From: Tim Townsend [REDACTED]
Sent: 12 December 2017 16:23
To: Michael Eastham
Subject: RE: LU/121/17/RES - Main Avenue Landscaping etc.

Please could I have your comments on the attached, amended Landscaping plan for Phase 2 of the residential development at North Littlehampton Strategic Development Area.

Tree Planting Details LA108

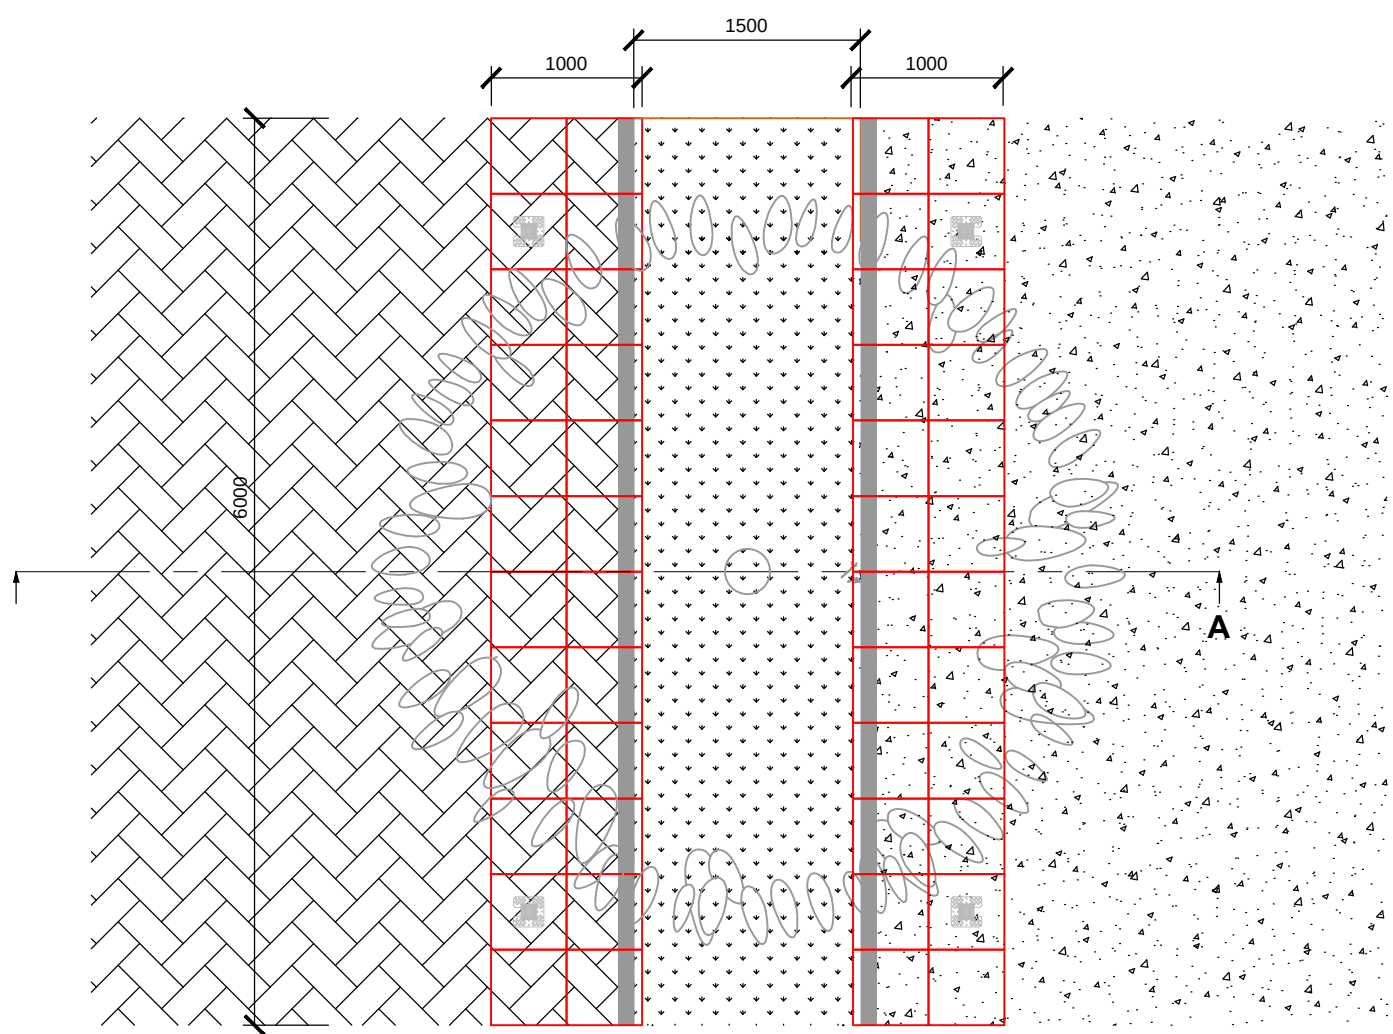
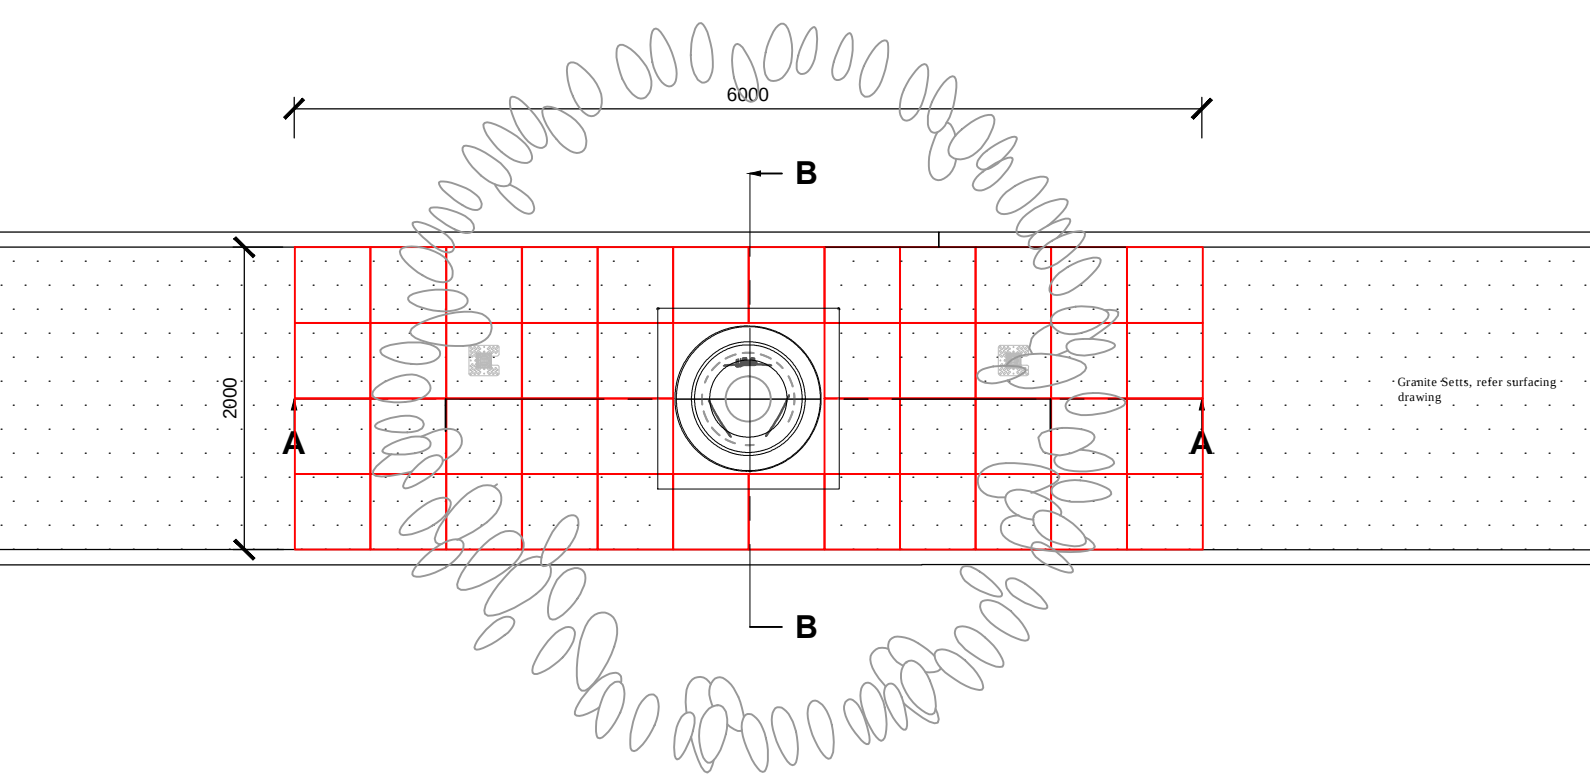
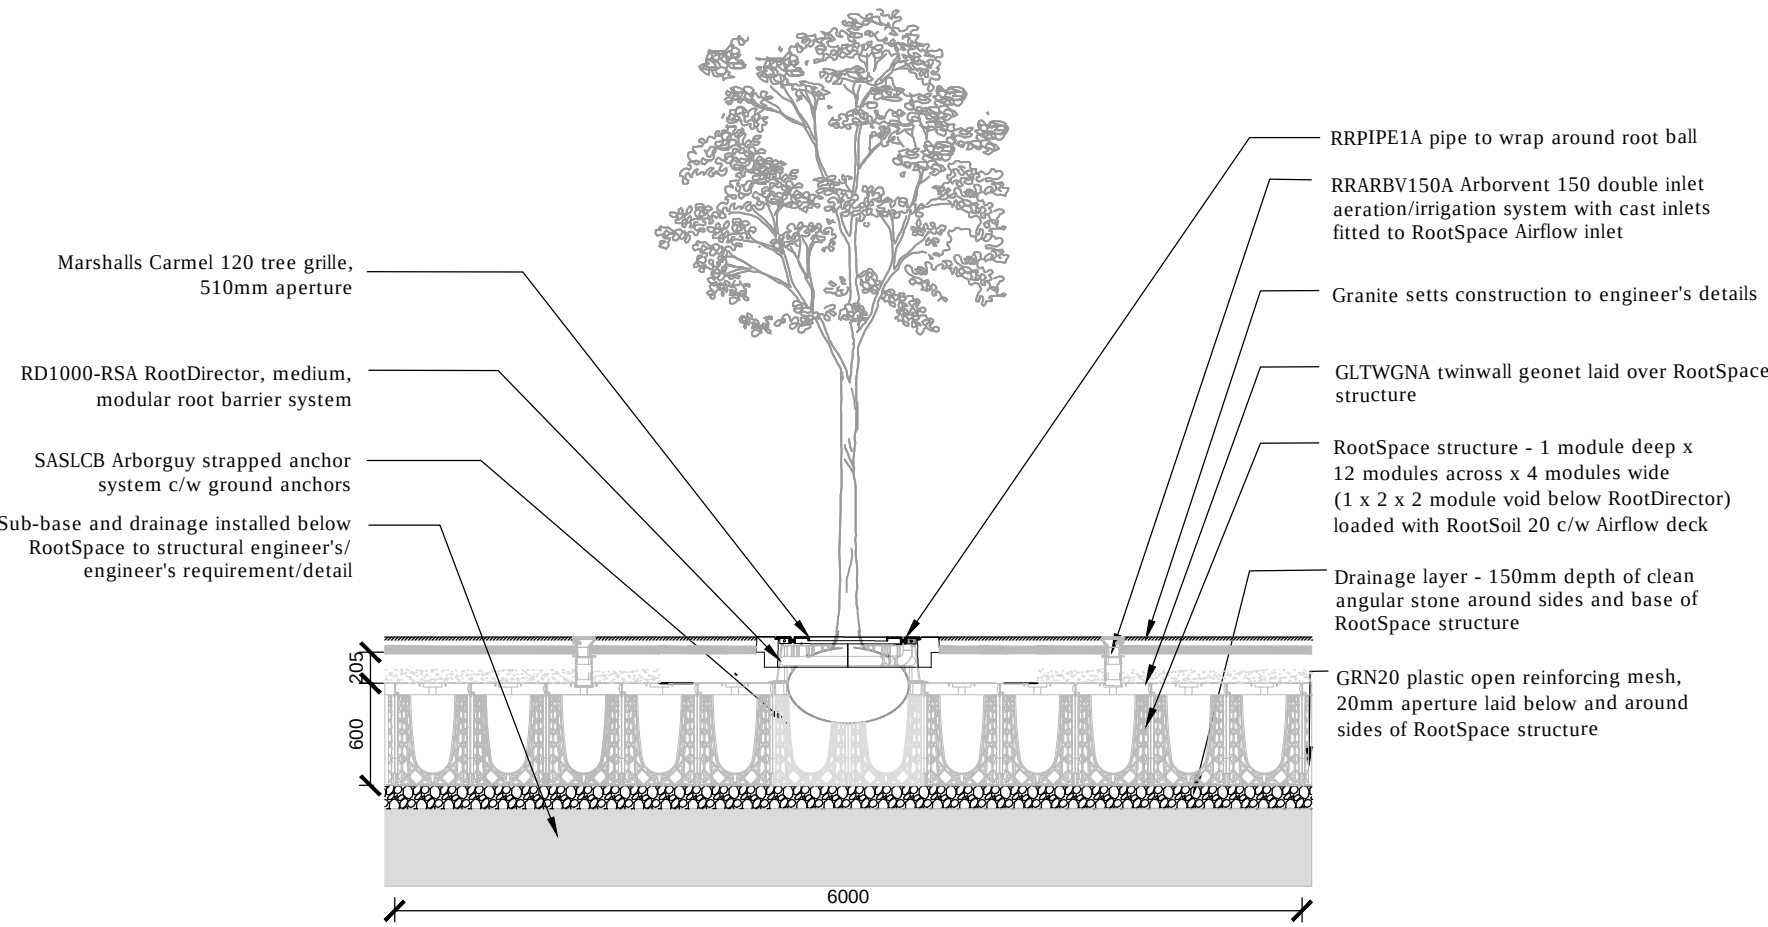
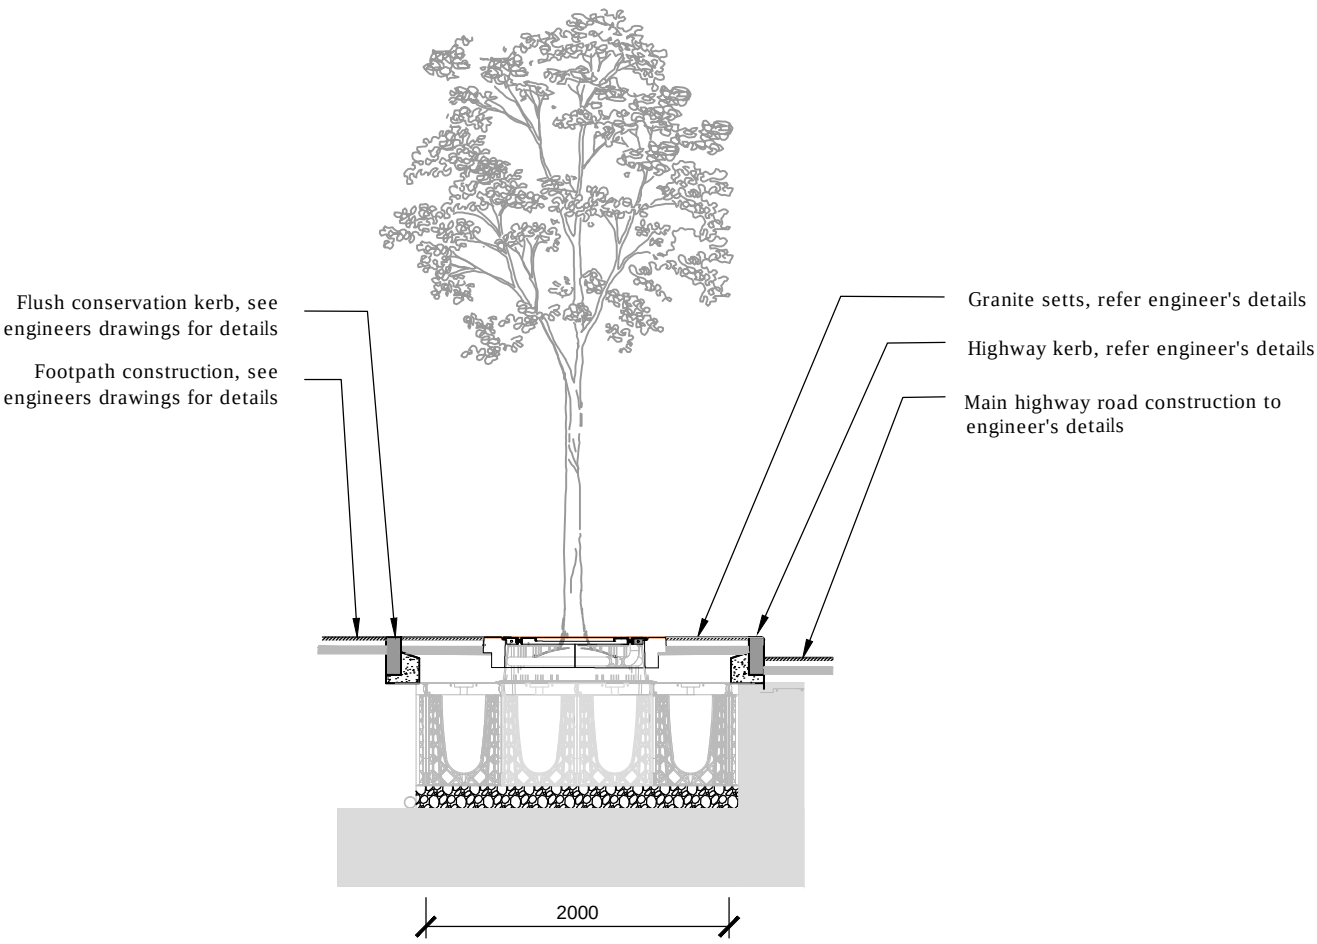
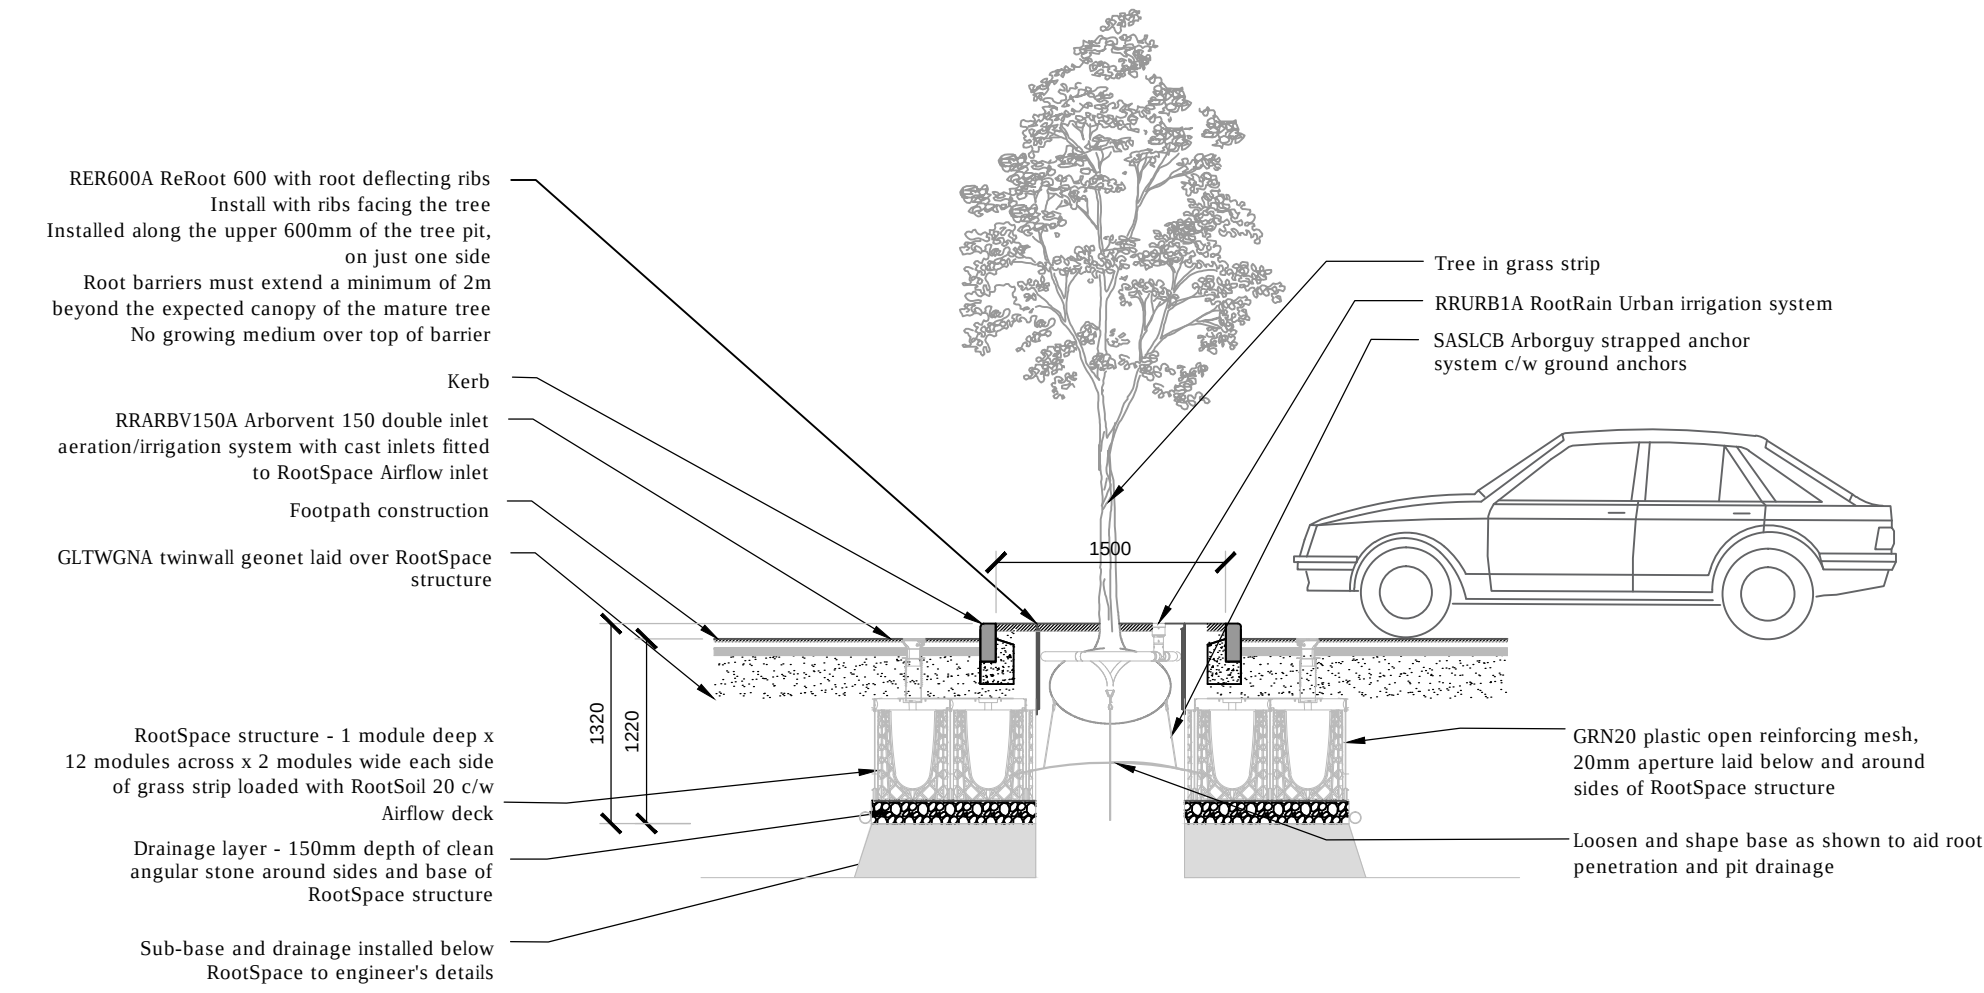
1. **Tree types** – must be clean (and narrow) stemmed up to 2.4m with no growth beneath when mature (to provide clearance for cyclists and pedestrians underneath).
2. **Street lighting** – Street lighting design and positions need to be considered carefully so as to not be obscured by tree canopies etc.
3. **Verge/hard landscaping areas** – A continuous verge would still be advantageous/preferred for tree root spread. Hard landscaping in-between trees can attract weeds etc. and might require additional maintenance (for which an additional commuted sum might be required). If used, Keyblok paving is acceptable to WSCC.
4. **Services** – must not run in verges nor hard landscaping areas where trees are proposed, nor roads (put them in footways/cycleways).
5. **Road Safety Audit (RSA)** – A Stage 2 RSA will be required at detailed design and/or S38/278 stage.

- 6. Fencing in verge or hard landscaping areas** – this should not be provided for safety and maintenance reasons.
- 7. Tree pits** – Design details of tree pits must be agreed at the detailed design/S38/278 stage prior to installation.
- 8. Commuted payments** – Will be required for tree and pit maintenance (will be worked-out at detailed design stage).
